Subject: Pemulwuy Mixed Use Development, Redfern (MP06_0101 MOD 1 & MP11_0093)

1. I have reviewed the Pemulwuy Mixed Use Development (MP06_0101 MOD 1 & MP11_0093) and the submitted plans on exhibition at the NSW Department of Planning & Infrastructure, 23 -33 Bridge Street, Sydney.

Proposed Shadow Diagrams June 21 (Winter Solstice)

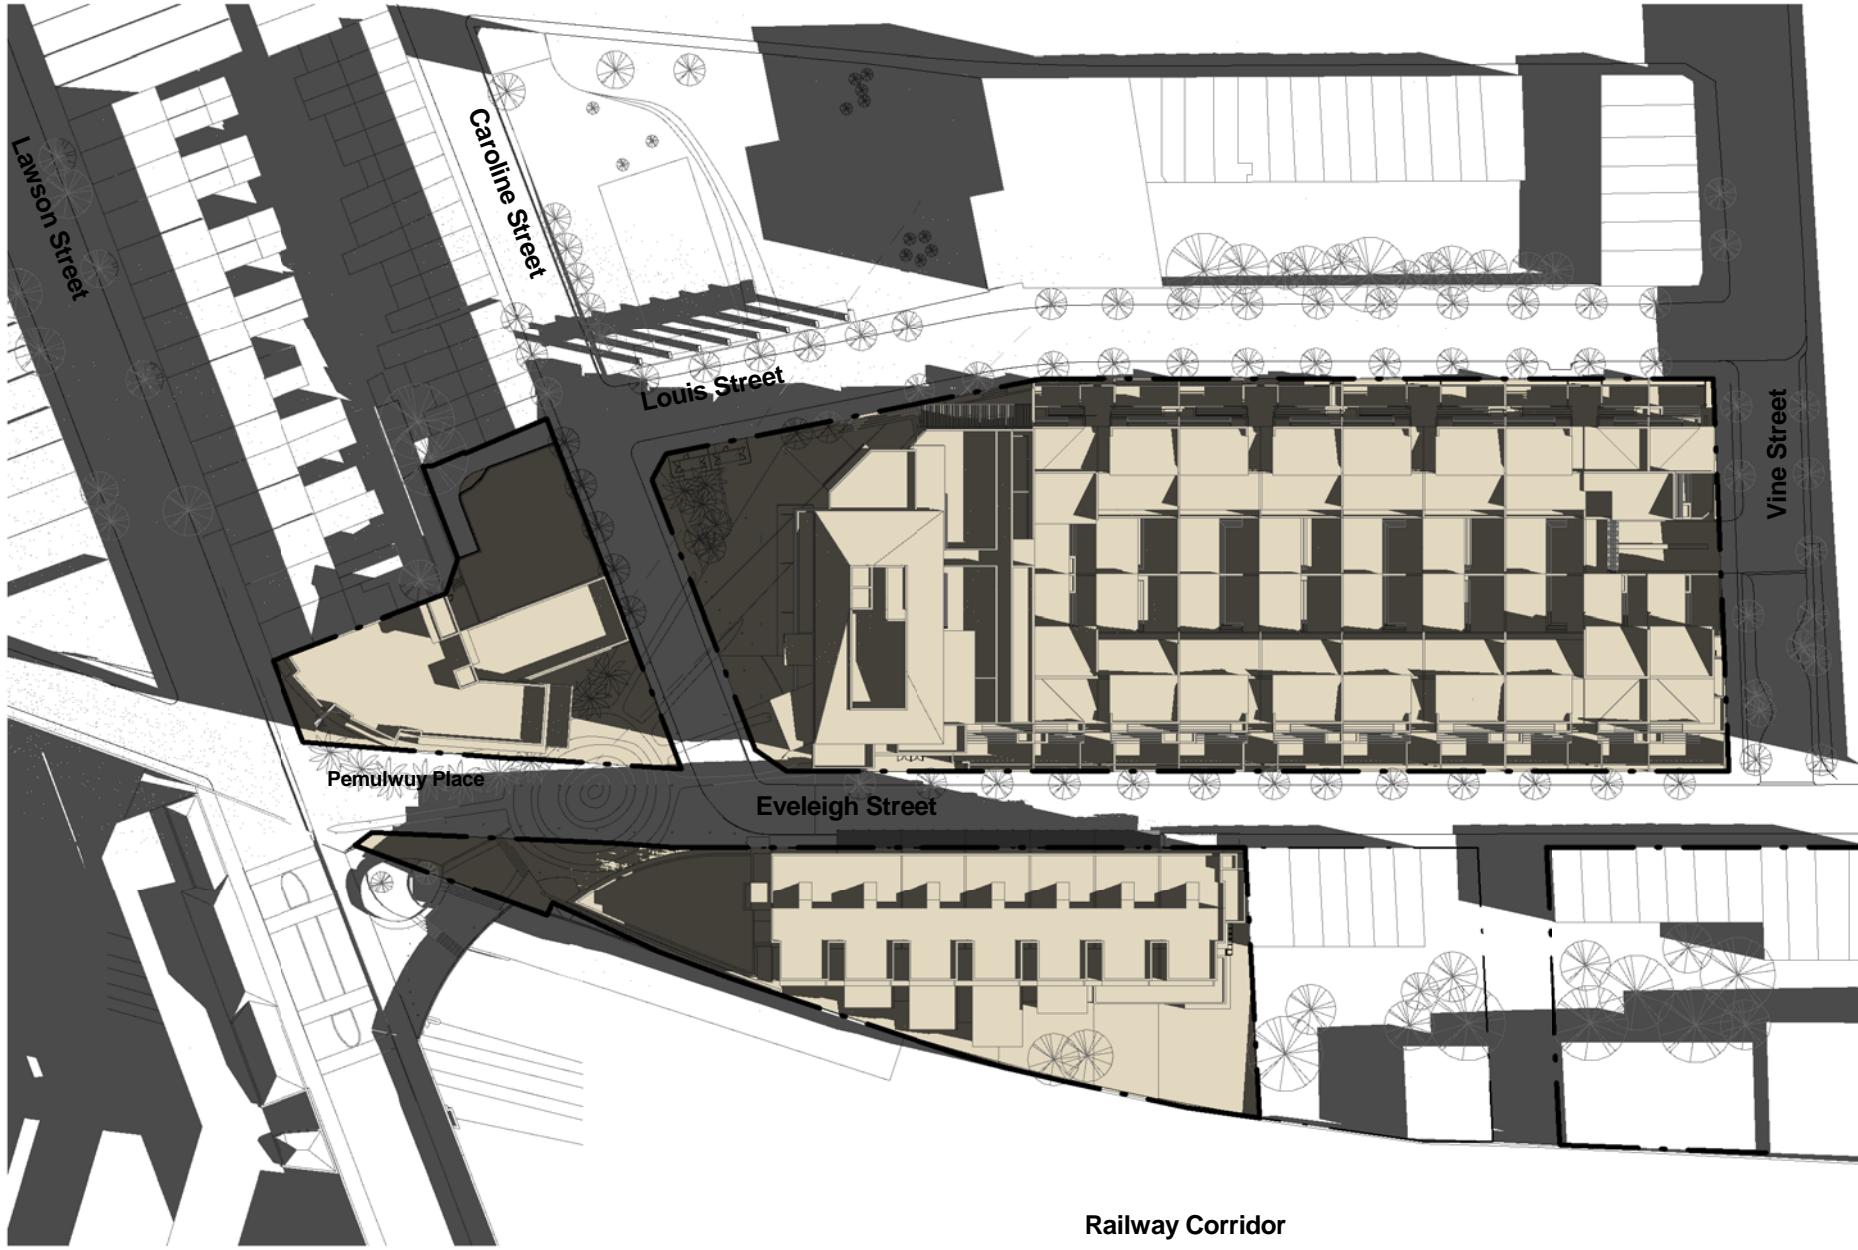
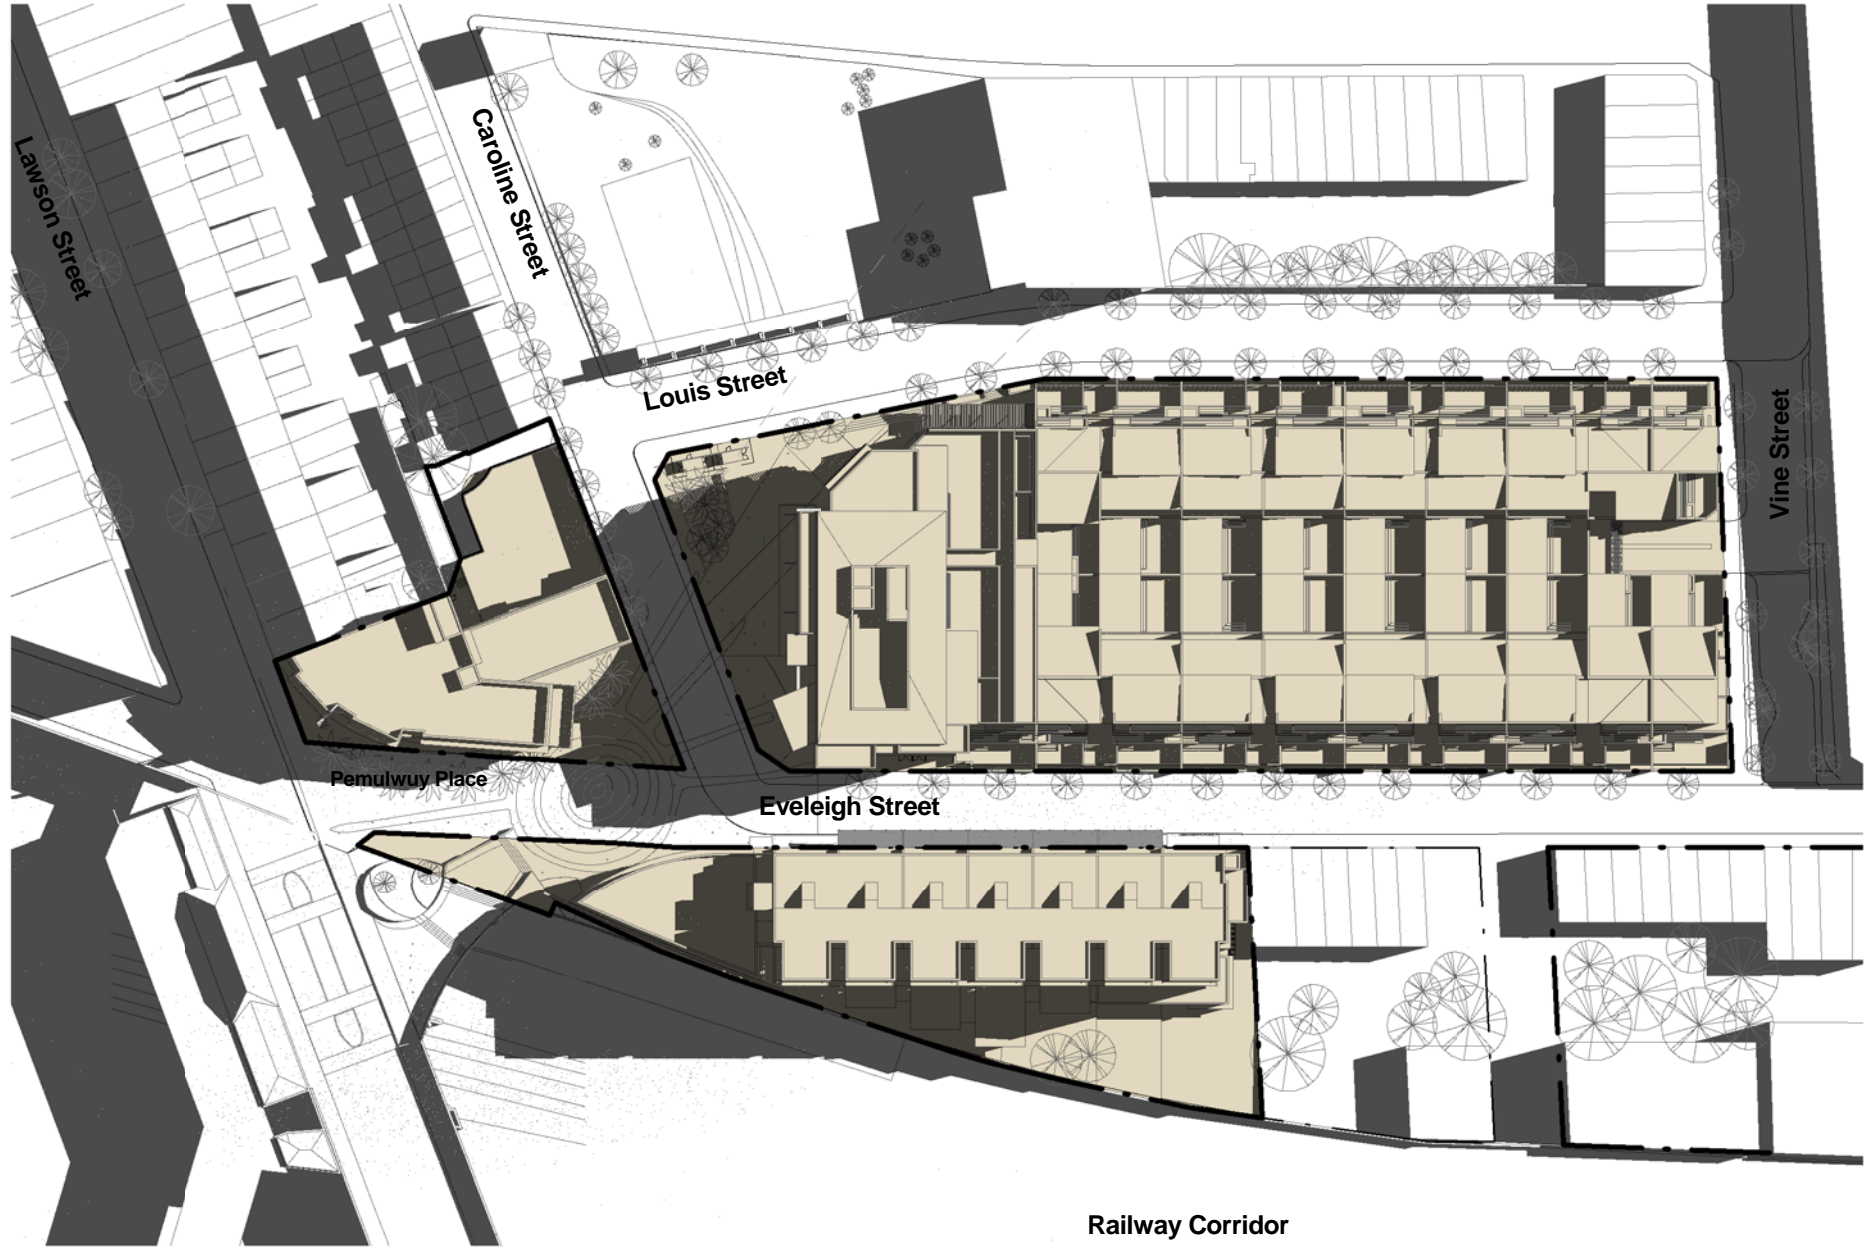
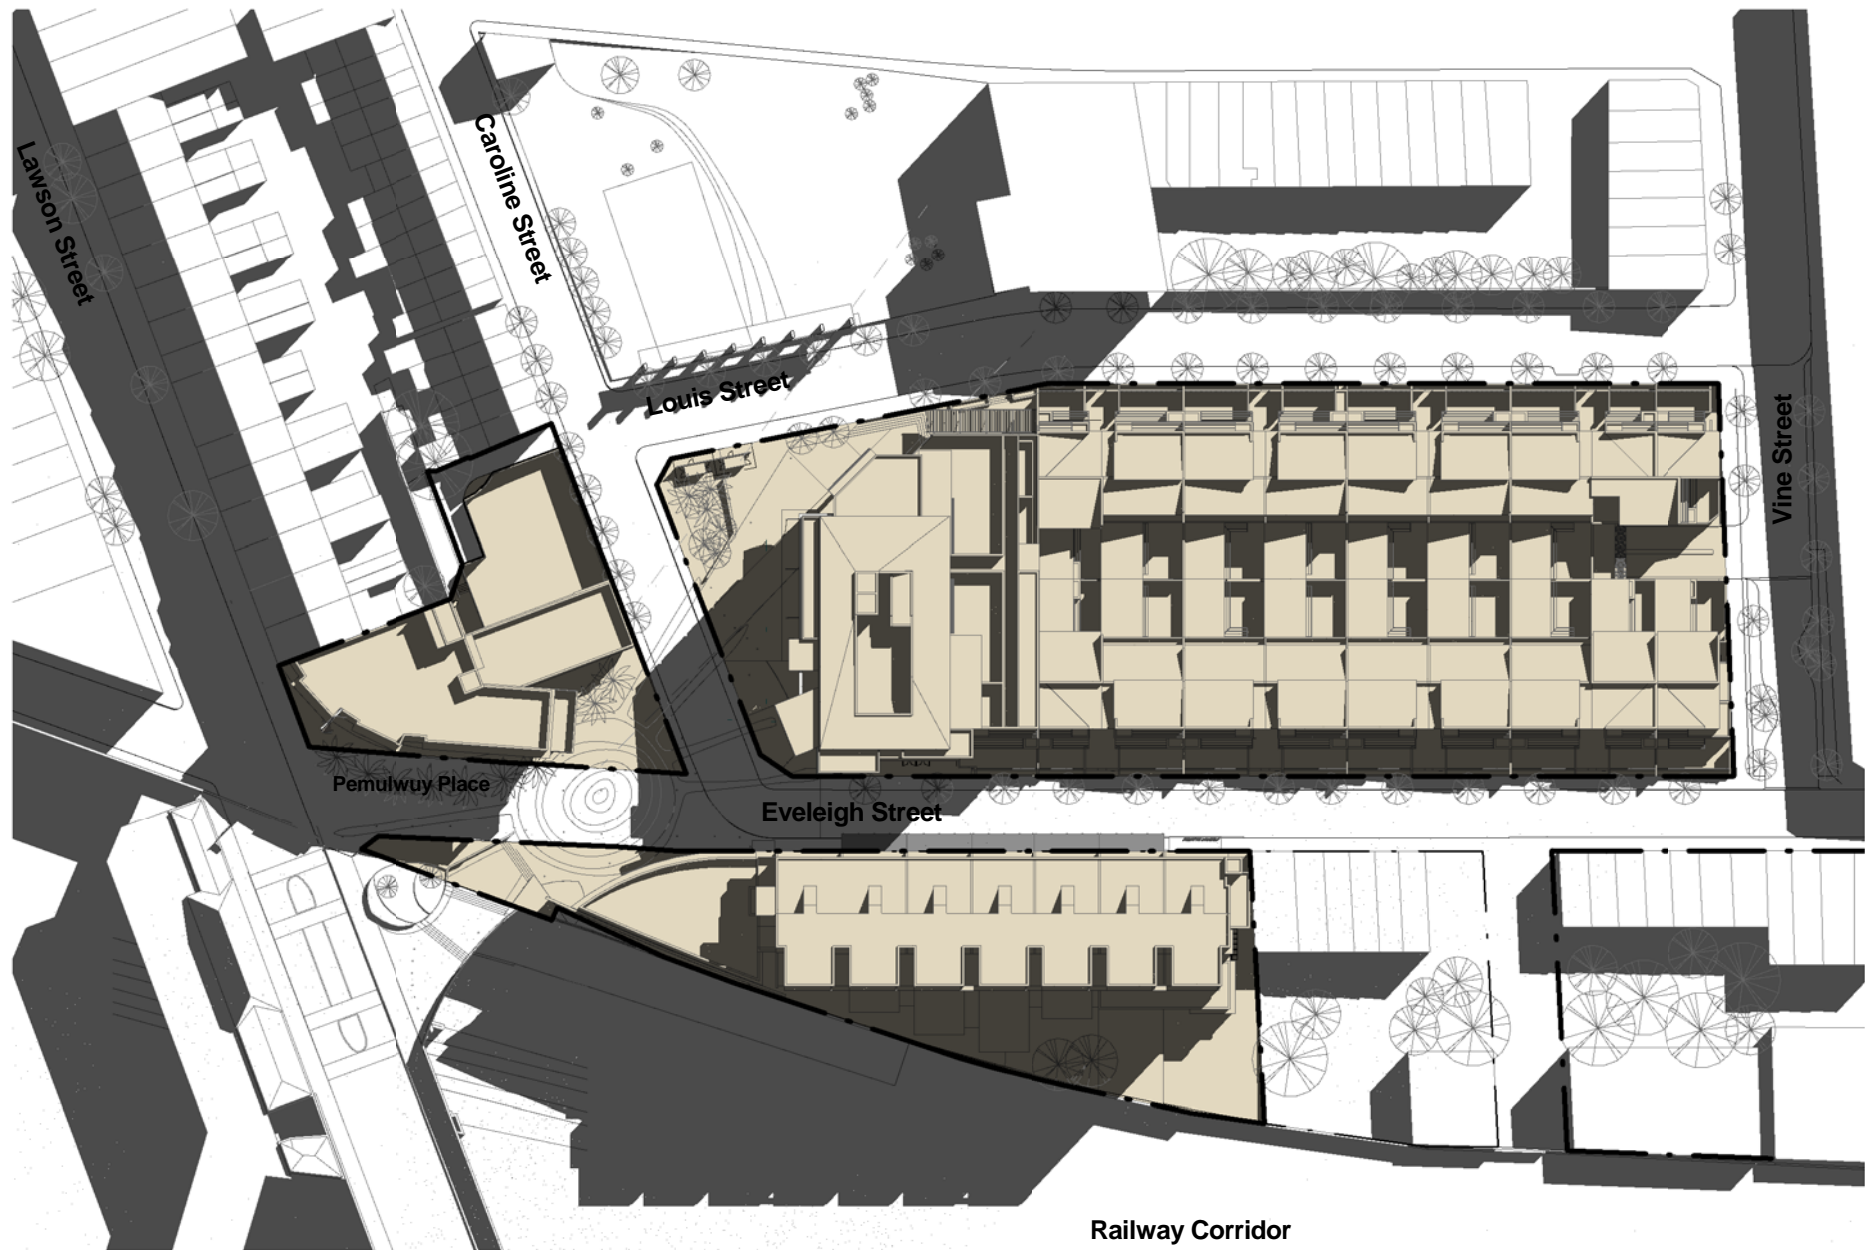
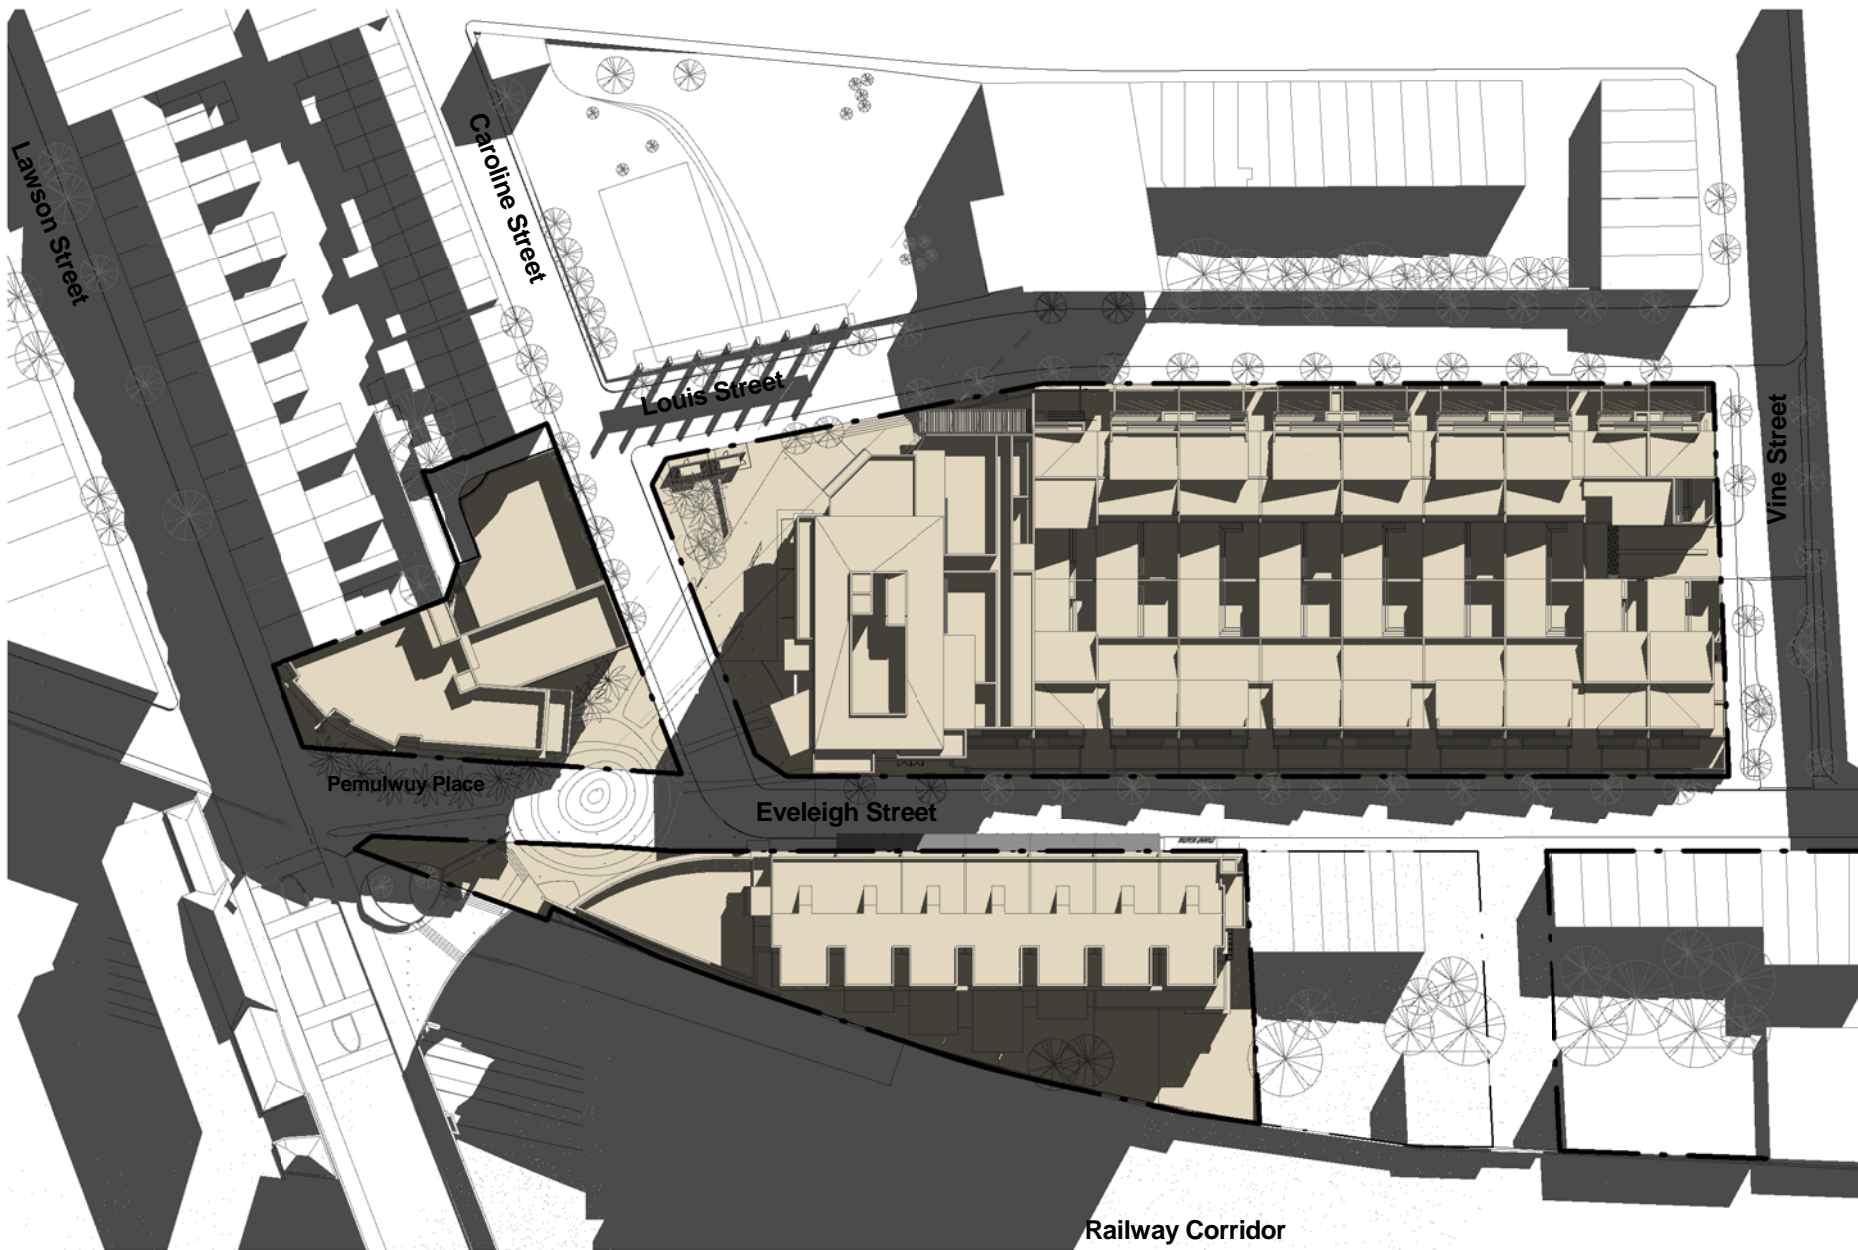
17. The Development contemplates:
 - a. a 6 story student accommodation on Eveleigh Street adjacent to the railway line; and
 - b. a large 6 storey mixed use tower at the top of Louis Street that incorporates a gymnasium.
18. These two buildings cast significant overshadowing of adjacent open space, roads, community areas, private property and even the proposed child care centre.
19. These buildings are significantly oversized for the area and are inconsistent with the zoning set by the Redfern-Waterloo Authority.
20. In my submission, the Redfern-Waterloo Authority zoning should apply with respect to the size and location of large buildings. ie large buildings should be located in the vicinity of Vine Street.

- g. the Development should not be allowed to overshadow public spaces, roadways, community areas and private property; and
- h. the AHC should consider a more modest and less complex development consistent with its level of expertise.
